From: Brian Greenwood [REDACTED]
Sent: 02 August 2012 16:44
To: Mike Harris
Cc: Able Marine Energy Park
Subject: TR030001 - Associated British Ports [REDACTED] - proposed Able marine energy park - comments and further representations

Application for the proposed Able Marine Energy Park on the south bank of the River Humber at Immingham, North Lincolnshire

Response to first stage Written Representations
in Respect of Terrestrial Ecology and
Nature Conservation

**Response to Comments on Relevant and Written Representations and 1st Round Examiner
Questions on Marine Matters**

Drawing file: published-documents / TR030001-000291-Quay General Arrangement.pdf

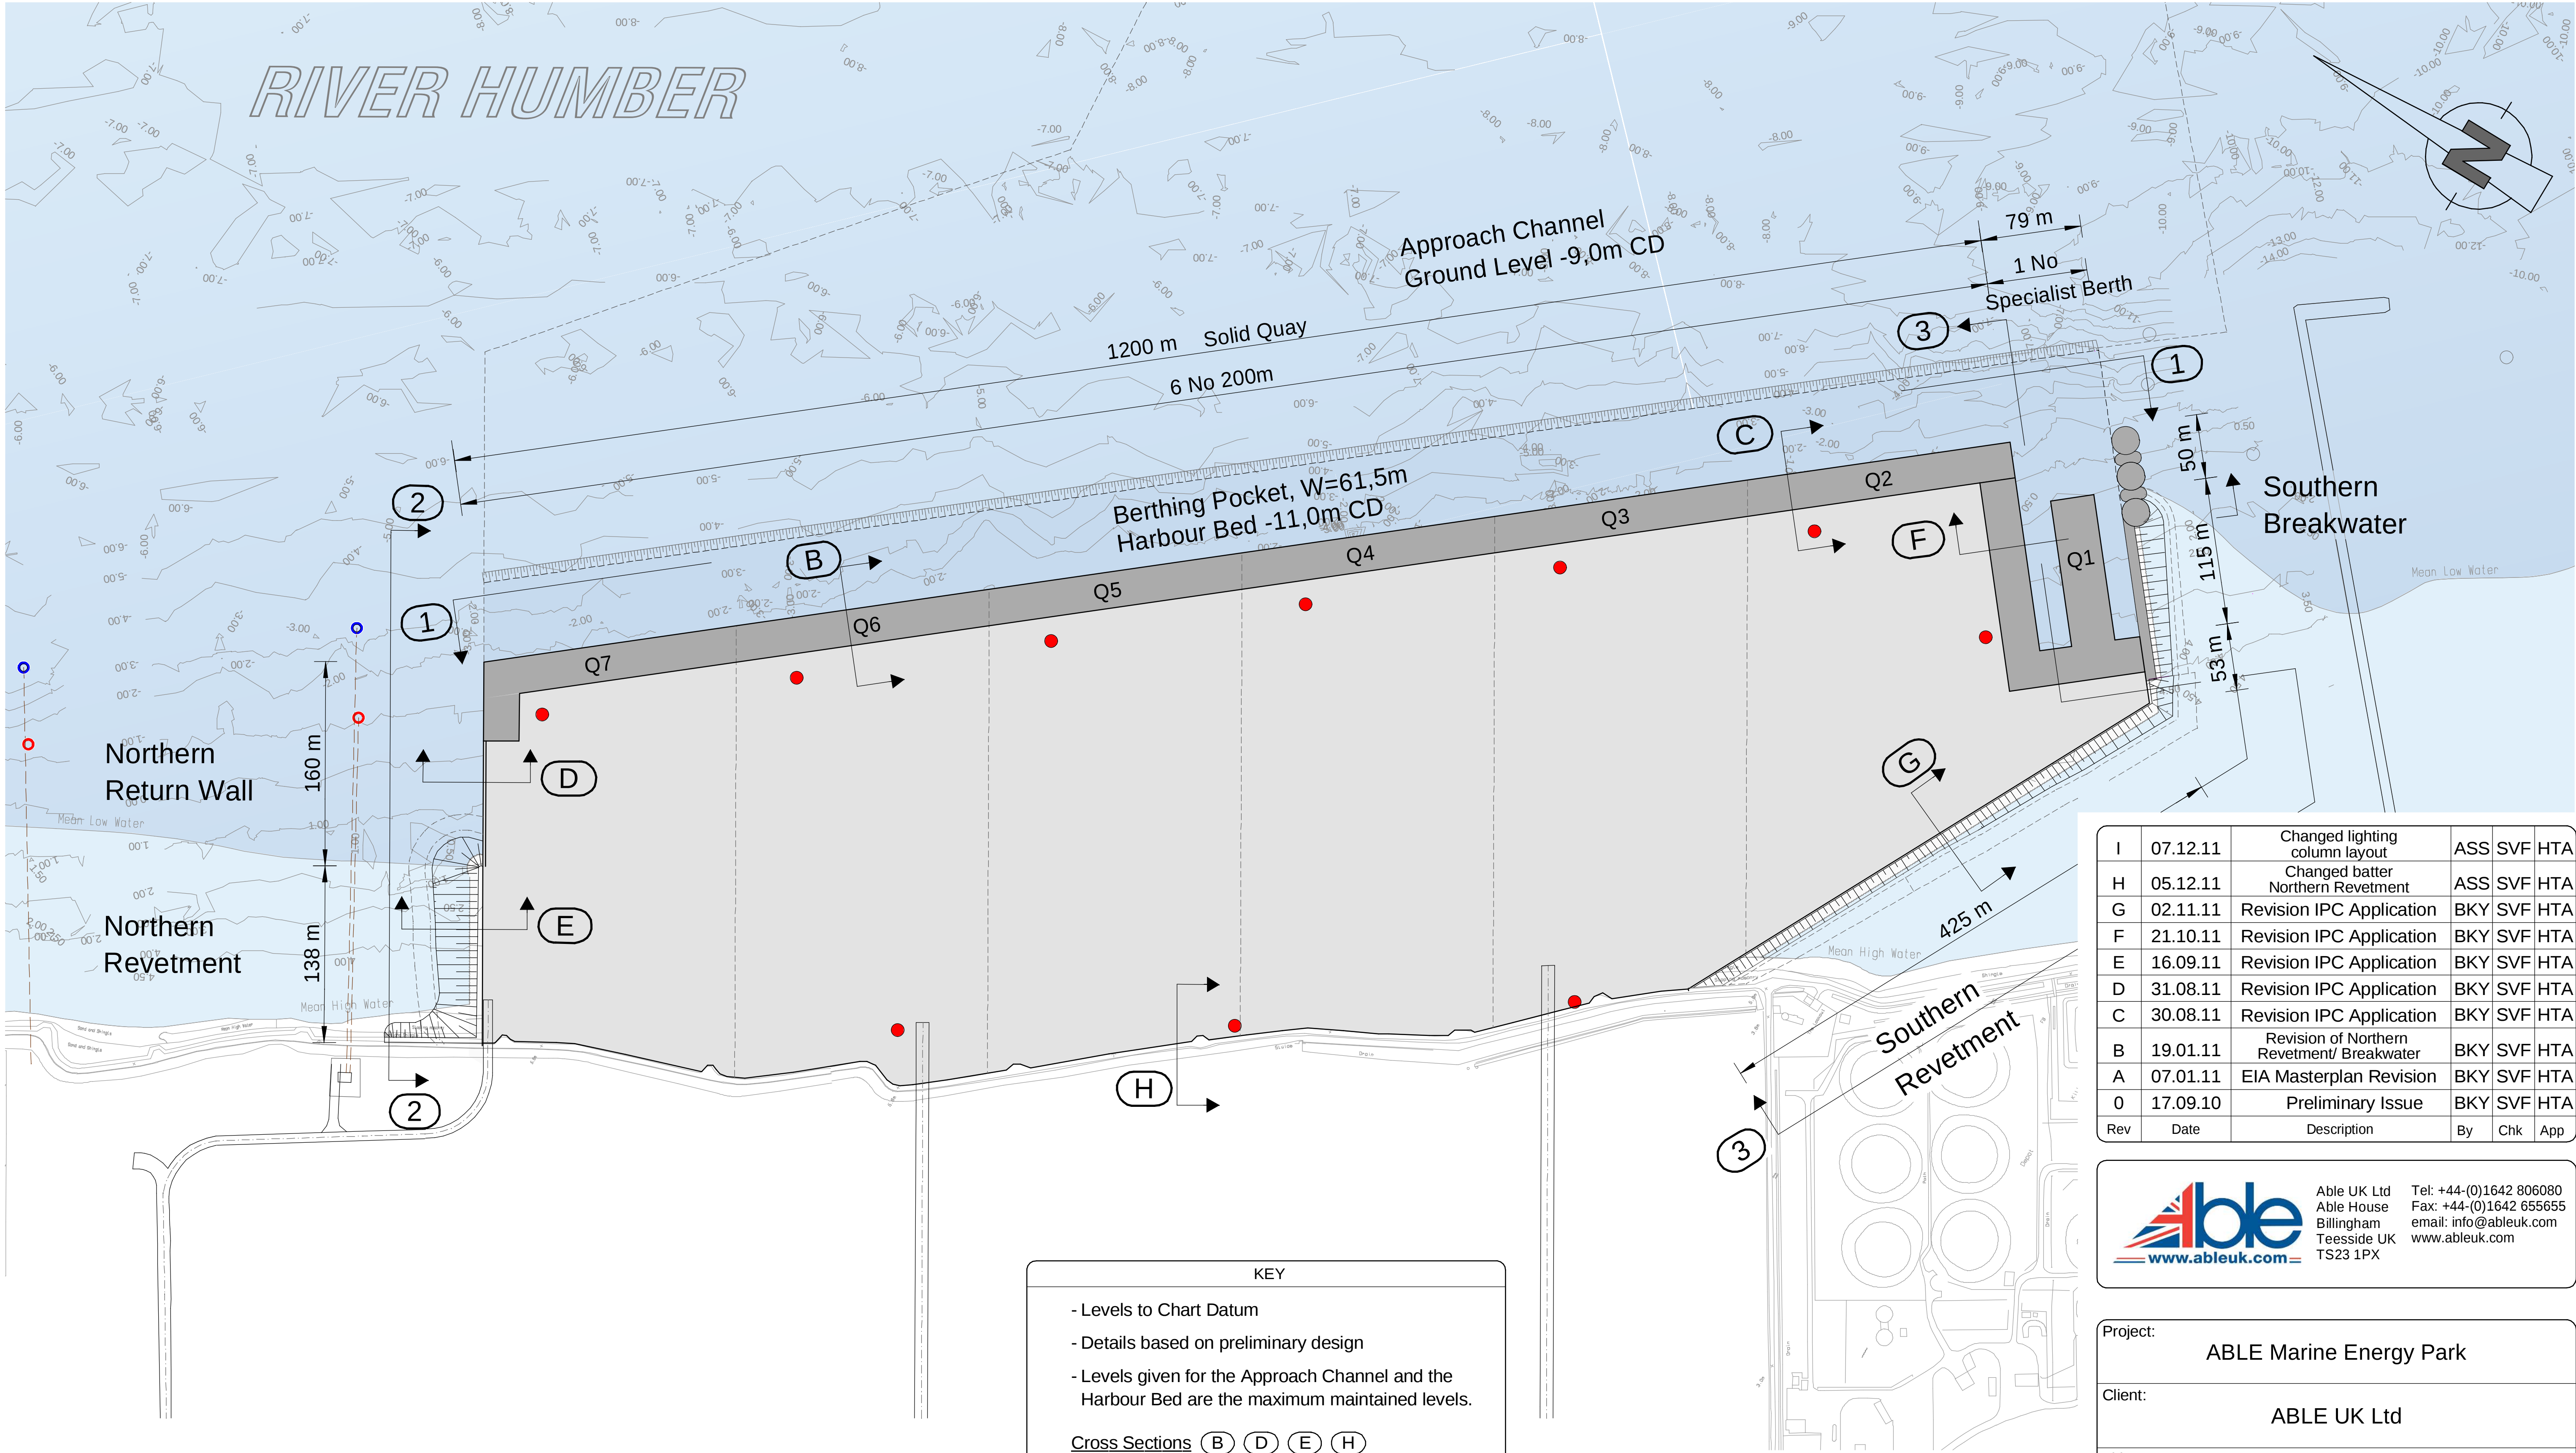
- 3.2. In Para 42.33 we accept that ABP were consulted on the proposal in general terms. The point being made in Para 7.2 of the ABP Relevant Representations is that the dimensions of the development (reclamation size and shape, dredge requirements) were being changed throughout the consultation. Accurate assessment of the potential effects and impacts of the project was, therefore, clearly impossible. As a consequence, the potential impact on the marine processes and sedimentary effects could in reality only be considered by ABP and the other consultees at the time of the application.

- 3.3. As I explained in my previous representations, the AMEP scheme design which was modelled for the ES was not the same for determining all the potential impacts that were modelled.

- 3.4. The process of optimising the design took account of only a limited number of potential impacts. In particular it seems to have been undertaken solely with respect to the Centrica/E.ON intake and outfalls. As such, it has failed to reflect other important impacts such as those on ABP facilities.

- 3.5. For example in the ES the effects on flows were assessed for a preliminary design whilst fine sediment transport was assessed for the final (DCO) design. Consequently the results are not

directly comparable and therefore impacts related to flow changes, e.g. those relating to navigation issues, which could impact directly on marine operations at the Port of Immingham, could not have been assessed using appropriate modelling results and are not correctly represented in the ES.

- 3.8. The argument put forward for no increase in sedimentation in IOH might be credible if the local baseline hydrodynamics had been correctly modelled and IOH had been correctly represented in the model. This does not, however, appear to be the case and the queries raised by ABP in this respect have not been answered by the applicant's response. If it had been included I would have expected to see the data from the model. This has not been provided.
- 3.9. The new report, EX8.7, is an attempt to justify the assertion that there will be no effect on IOH. However, comparison of equivalent diagrams from this new report and the original modelling presented in the ES, (Figures PW2 and PW3 respectively attached), show distinctly different

patterns of effect on the local flow regime. Figure PW2 is the new modelling with the DCO development design and Figure PW3 is the ES presented design, which was inferred in the ES as the worst case. It should also be noted that IOH and the jetty structures appear in the new modelling but are absent from the ES. This supports our view in 7.2 (b) of the Relevant Representations that the works have not been correctly reflected in the ES nor properly assessed. As I indicated in Para 1.1, I have not had an opportunity yet to determine whether the new modelling has been properly undertaken and support the assertions made about it and in particular whether it has properly assessed IOH and the jetty structures, assets that are critical to marine operations at the Port of Immingham.

- 3.10. This confirms our view that DCO design gives rise to different potential effects on the marine environment to those presented for assessment in the ES. On this basis the ES does not give a true representation of the local hydrodynamic effects of the AMEP development and must as a consequence be viewed as fundamentally flawed.
